Reimers, PPR-19-041

Please accept the following comments from El Paso County Public Health for the project referenced above:

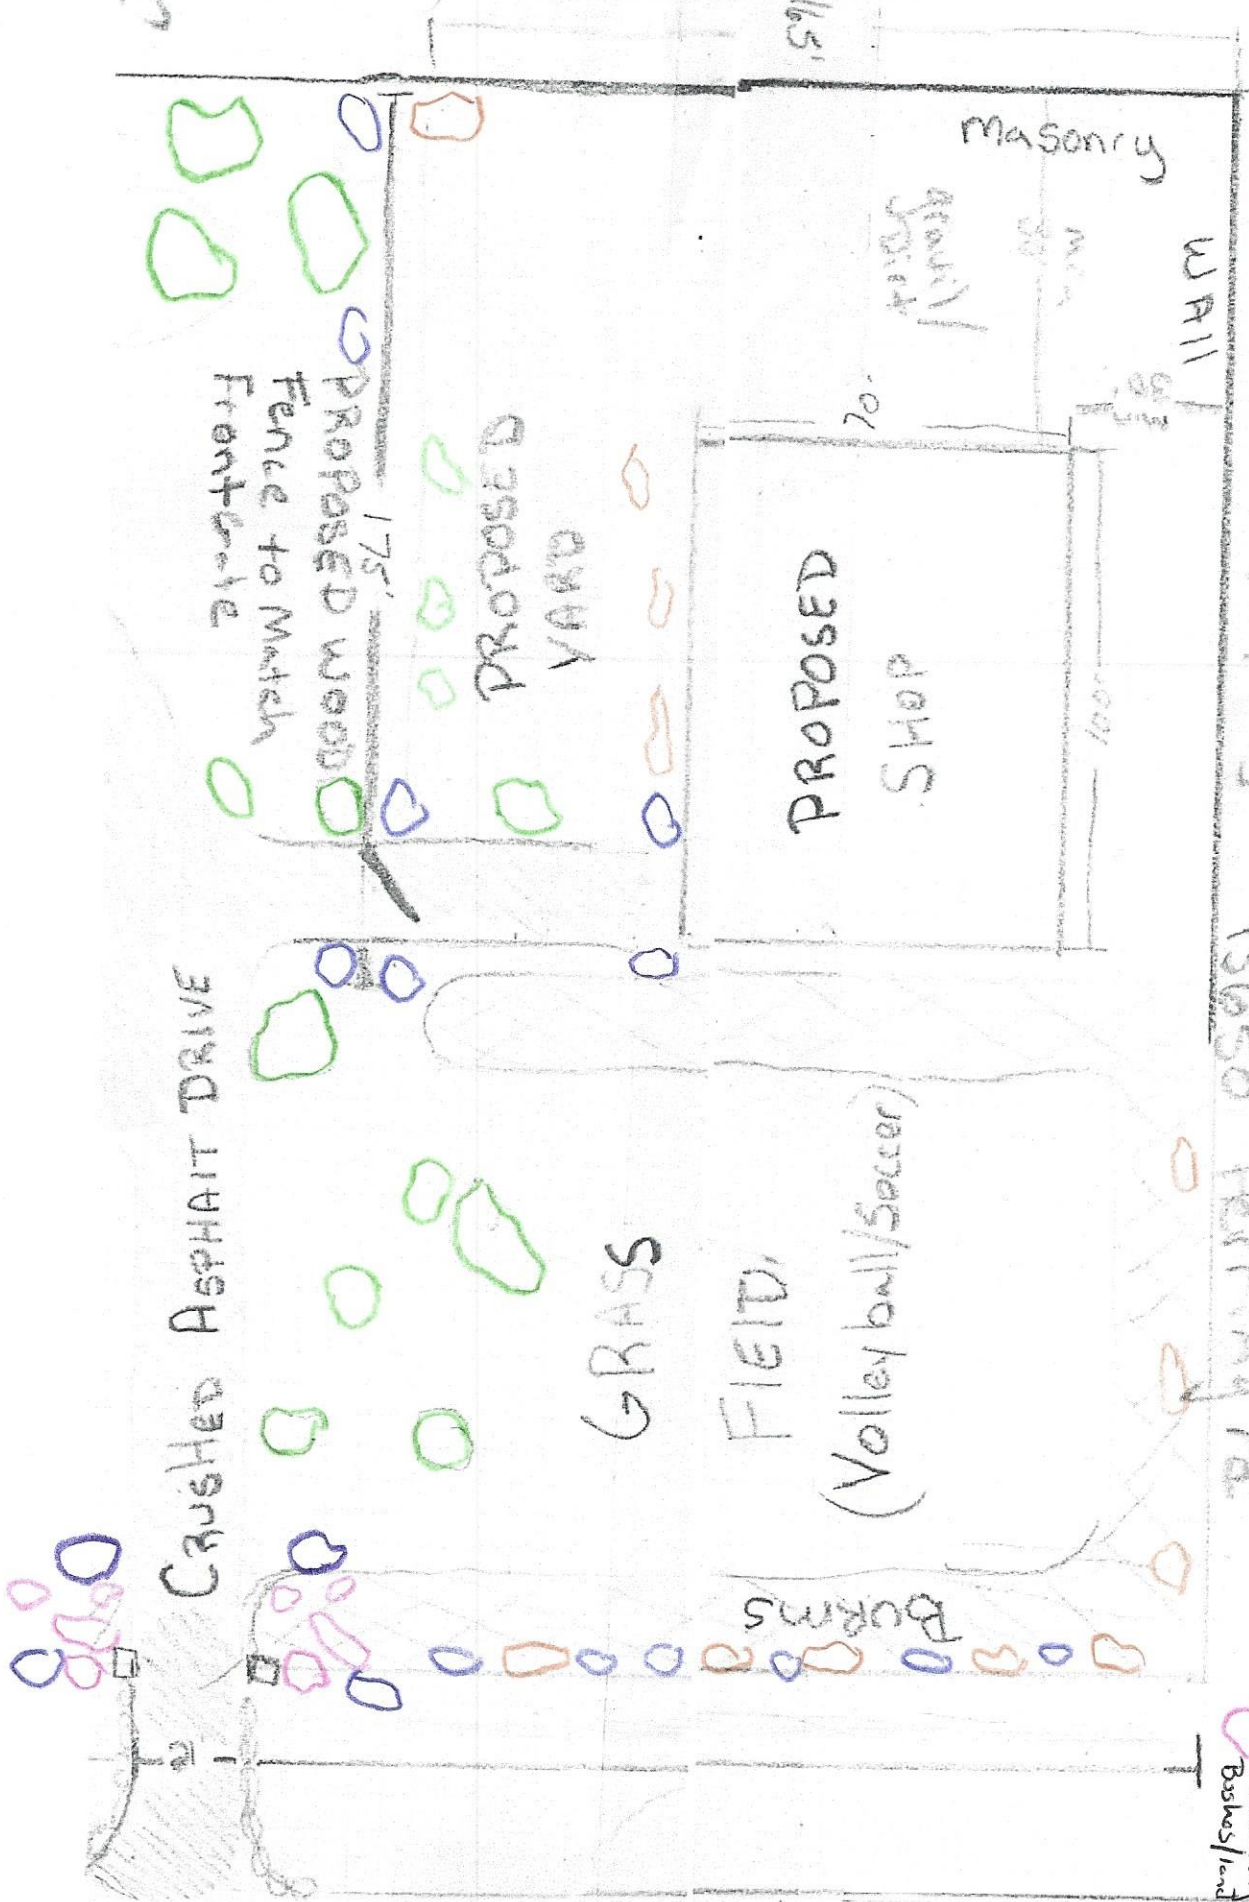
- **The permitted and approved onsite wastewater treatment system (OWTS) was installed in 2004 and sized for a 4-bedroom house. The soil treatment area (STA) is located southwest of the house. Do not use this area for any parking, roads or storage that could cause compaction to the soil treatment areas. A map of the OWTS components is available on the El Paso County Assessor's Office website.**
- **There will likely be a restroom planned for the proposed future shop. The OWTS for the shop will require full compliance with the OWTS Regulations. The Letter of Intent mentioned the necessity to comply with all codes.**
